# Conservation Area Advisory Committee

Meeting Date : 7 September 2015

| Ref                                                                                                   | Description                                                                                                                                                                                                                                                                   | Address                                                                                 | Design award |
|-------------------------------------------------------------------------------------------------------|-------------------------------------------------------------------------------------------------------------------------------------------------------------------------------------------------------------------------------------------------------------------------------|-----------------------------------------------------------------------------------------|--------------|
| AB/109/15/L                                                                                           | Application for Listed Building consent for change of u

BLOCK PLAN 1:500 @ A4

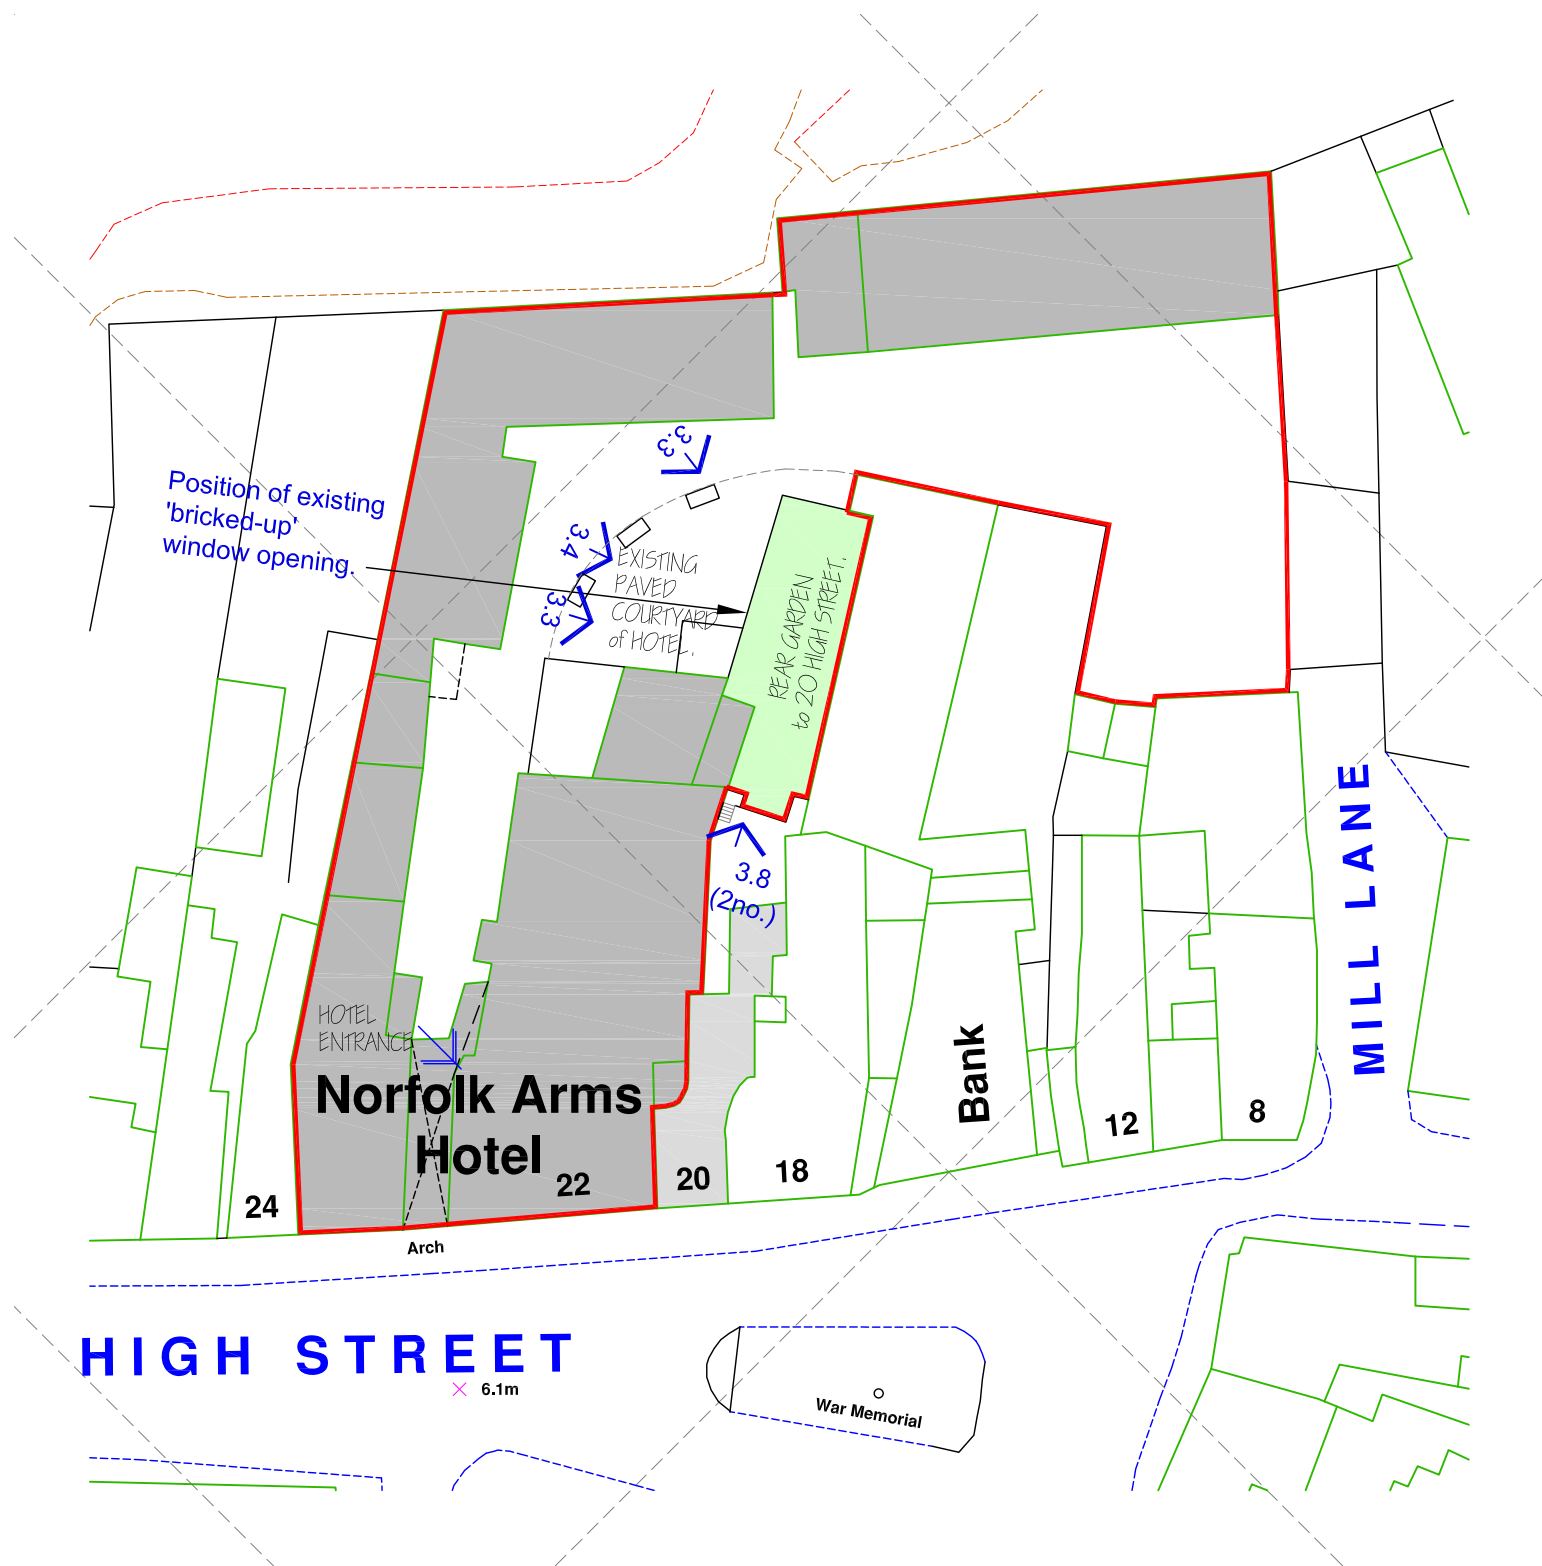
| Ref                                                                                                   | Description                                                                                                                                                                                                                                                                   | Address                                                                                 | Design award |
|-------------------------------------------------------------------------------------------------------|-------------------------------------------------------------------------------------------------------------------------------------------------------------------------------------------------------------------------------------------------------------------------------|-----------------------------------------------------------------------------------------|--------------|
| Comments: <i>No objection</i><br><br>Suggested Conditions: <i>Grow plants up the fence to hide it</i> |                                                                                                                                                                                                                                                                               |                                                                                         |              |
